From: Planning_THM <Planning_THM@environment-agency.gov.uk>
Sent: 19 April 2024 11:39
To: Dean Swann; Planning; Linda Griffiths
Cc: Katherine Miller; Louise Steele
Subject: RE: 10682 RE: CONSULTATION RESPONSE : 21/01119/OUT Our ref : WA/2021/129037/04

Subject: 10682 RE: CONSULTATION RESPONSE : 21/01119/OUT Our ref : WA/2021/129037/04

EA Flood Model Undefended scenario 1 in 100yr +15%CC

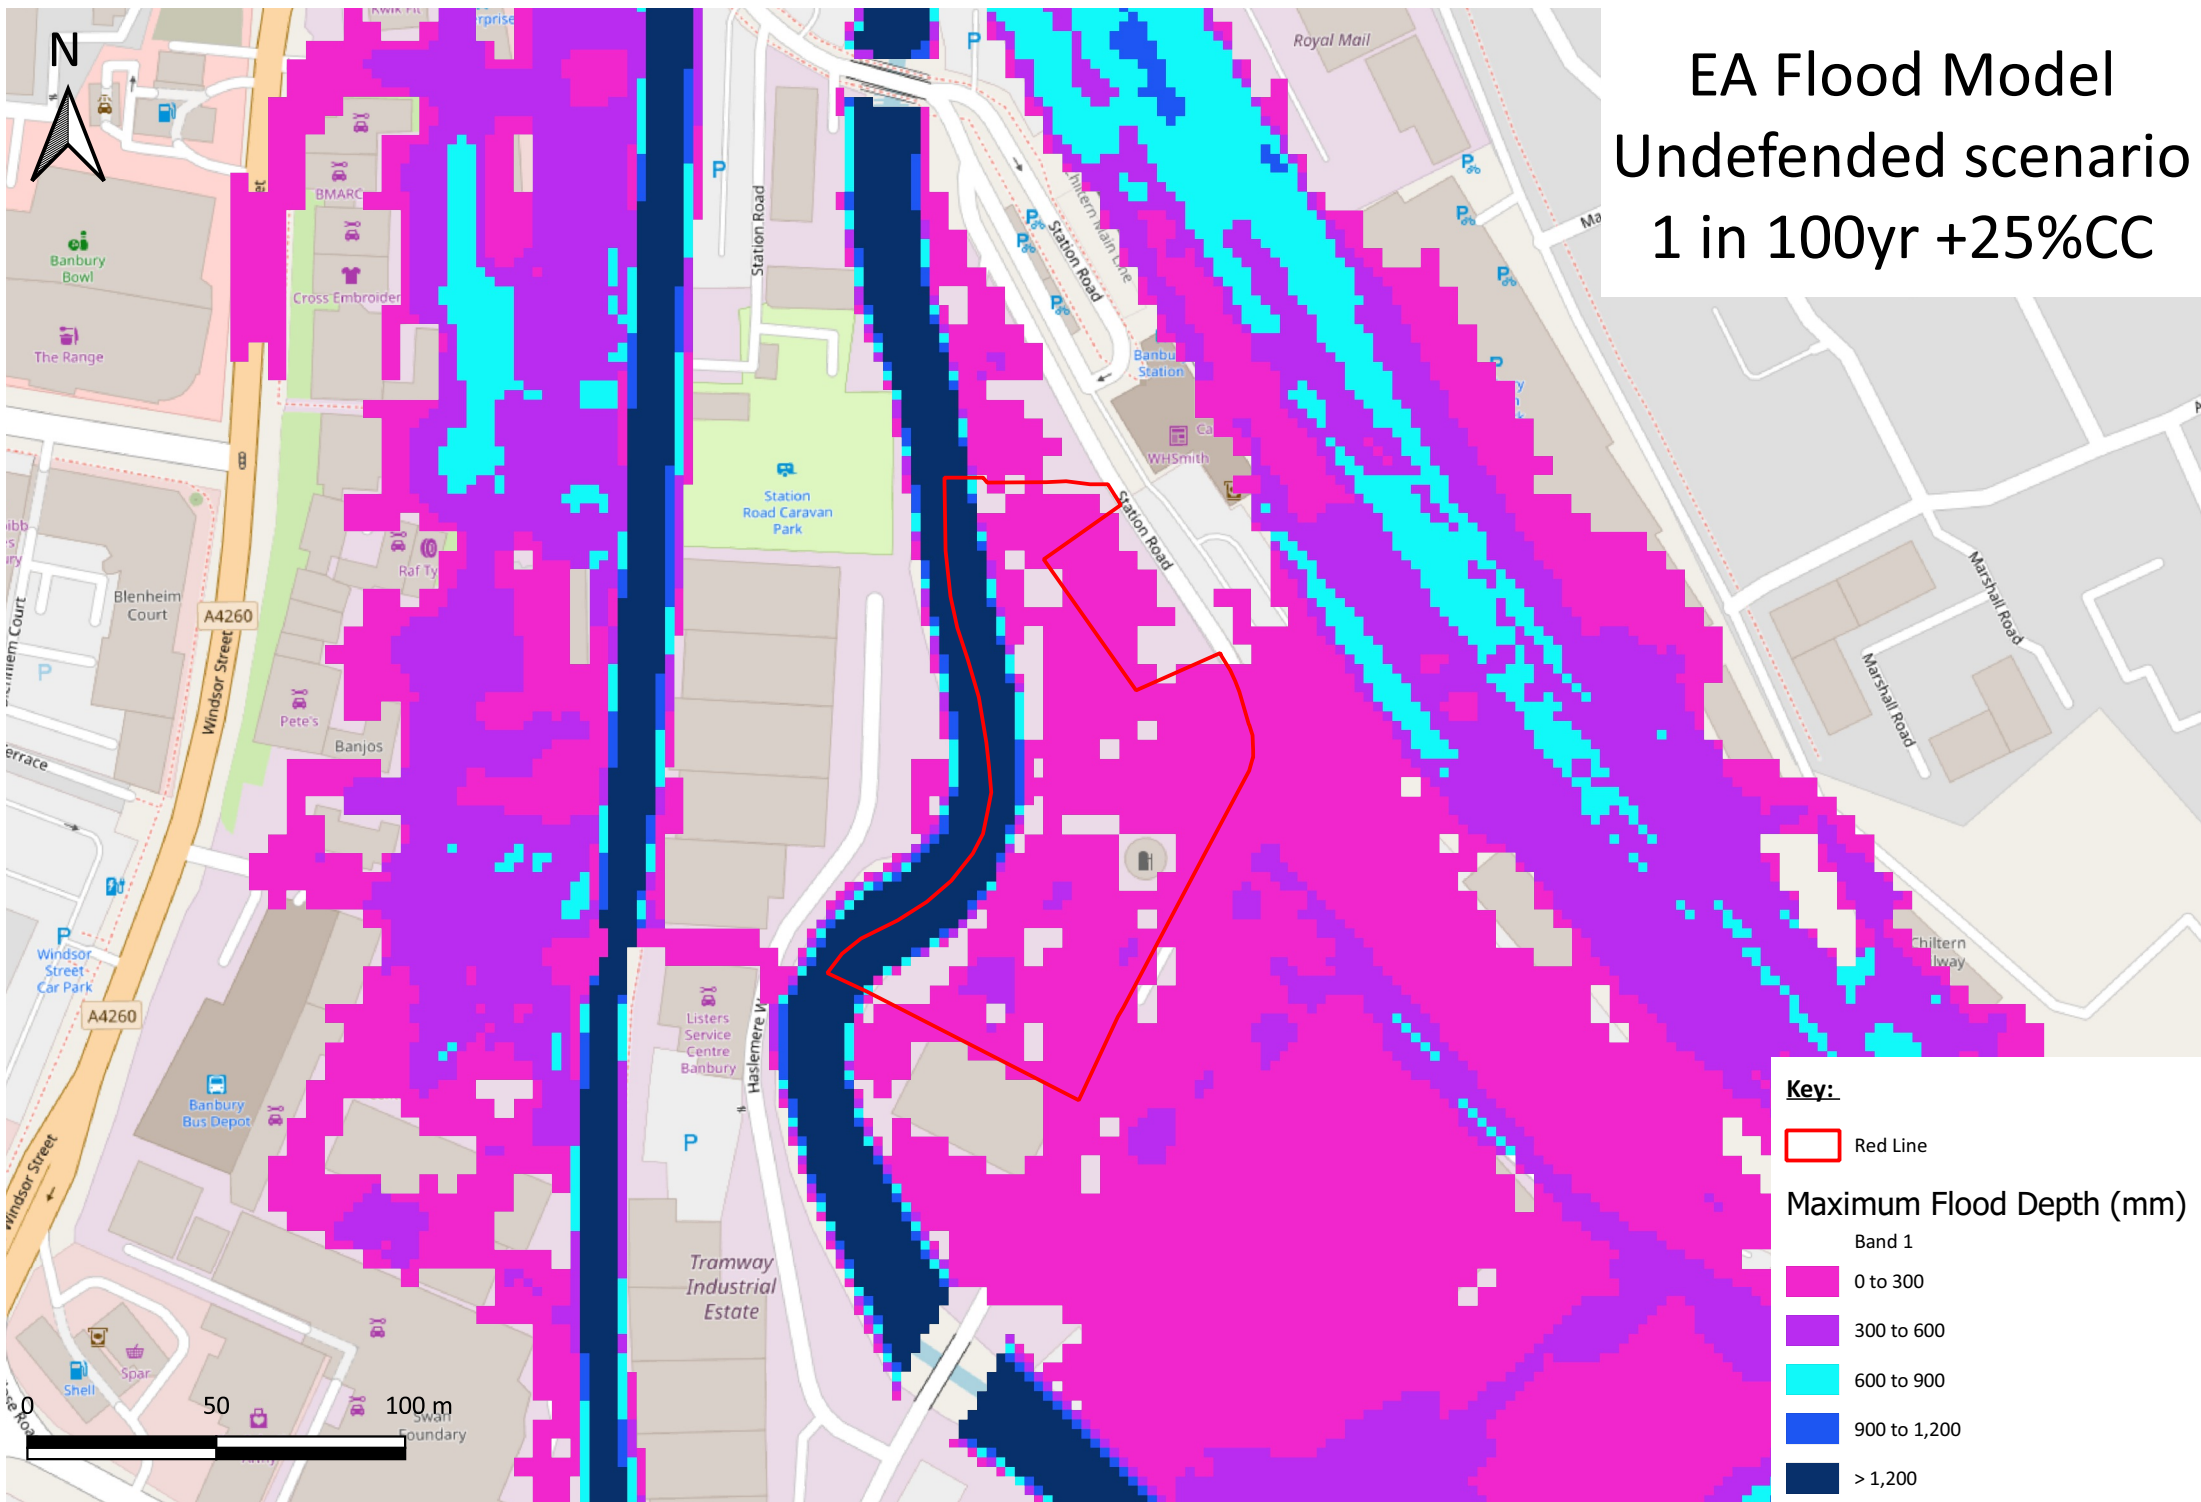
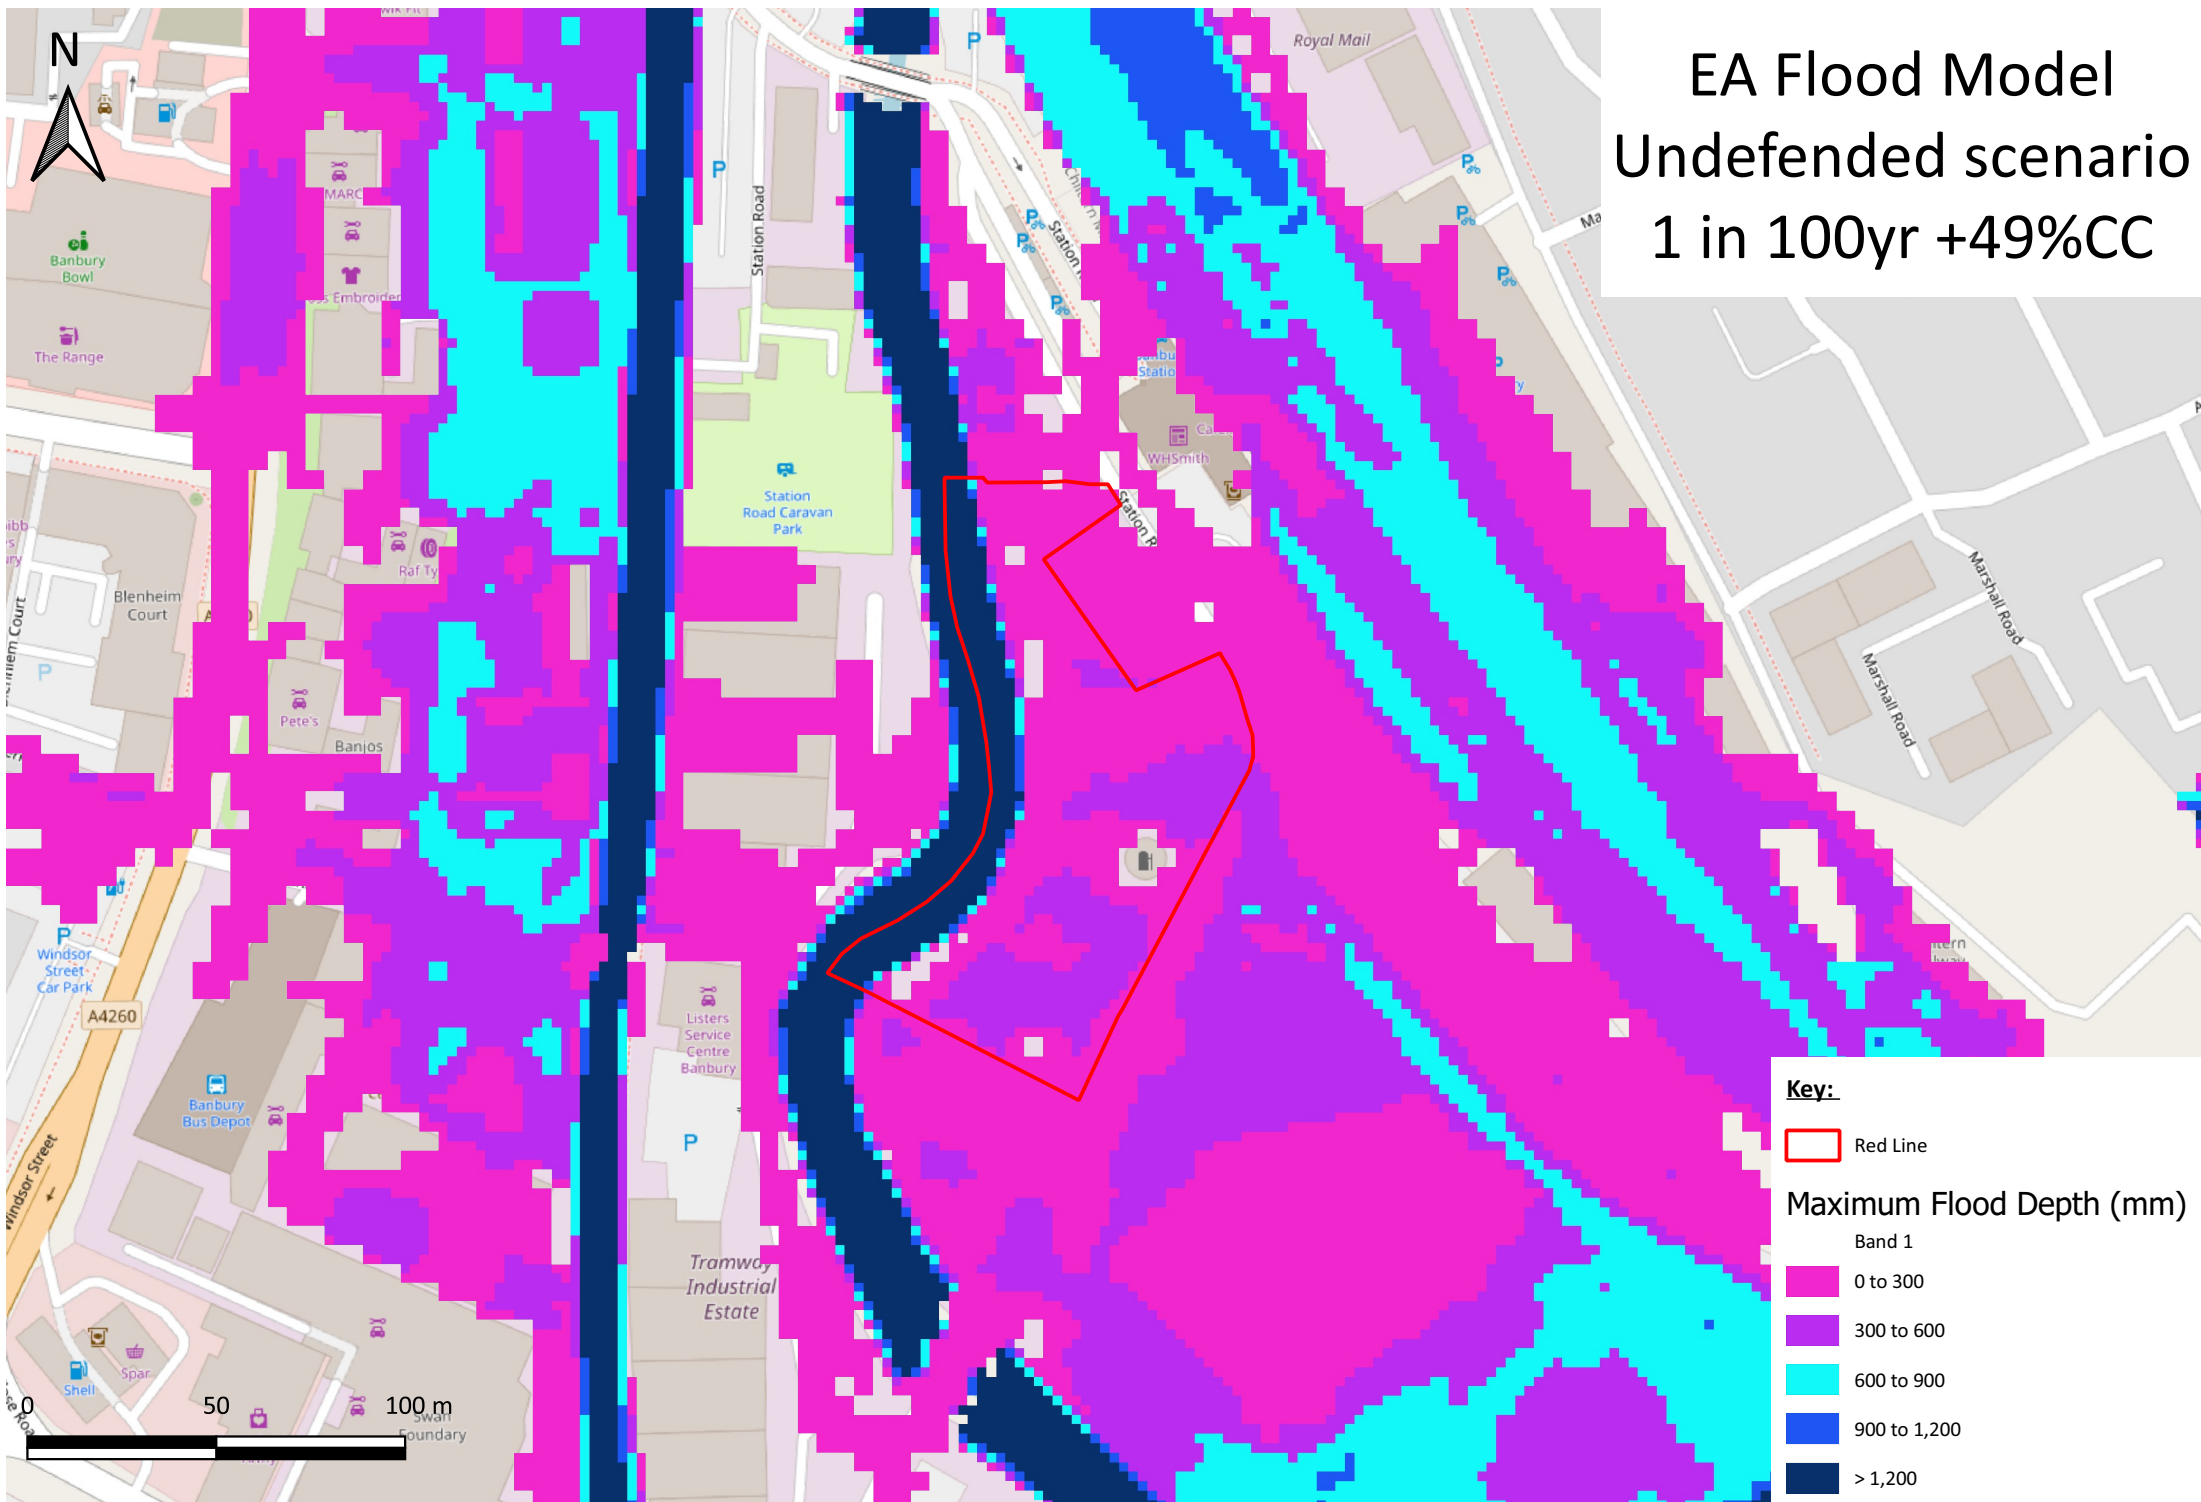
We don't understand why reference continues to be made the 49% cc scenario, this isn't necessary. Based on the current guidance for considering climate change for this catchment, you should model and map both the higher cc allowance (25%) and central cc allowance (15%) based on detailed site topography. Our best available modelled data shows there is an area of flood zone 3b (functional floodplain) along the river corridor. This is one of the reasons why 25% allowance should be considered. If all development can be accommodated outside of this extent (25%), avoiding the need for compensatory storage for lost floodplain, we would have no issue. If development is being proposed within this baseline extent, a loss of flood storage would occur and this will need to be compensated for and considered given if development within this extent would increase risk to the rail line and station. In this scenario, the compensatory flood storage would need to be designed to the higher cc allowance (25%). This is when a post scheme model would be needed alongside a detailed FRA.

Fundamentally, if we develop the site we have a larger footprint than there is there today. This being the case, any building, will by its very presence, displace more water during an undefended flood event than the site today. The site being a small city centre site is so enclosed, offsetting the volume in the flood plain is simply not going to be viable. Please see above comment. The sequential approach to the layout of the site is the best defence against flooding and our recommended option. If all development can be accommodated outside of the 25% cc extent then no flood storage will be lost. We would insist that no land raising takes place within the cc extent to ensure alterations in ground level doesn't itself lead to a loss of flood storage.
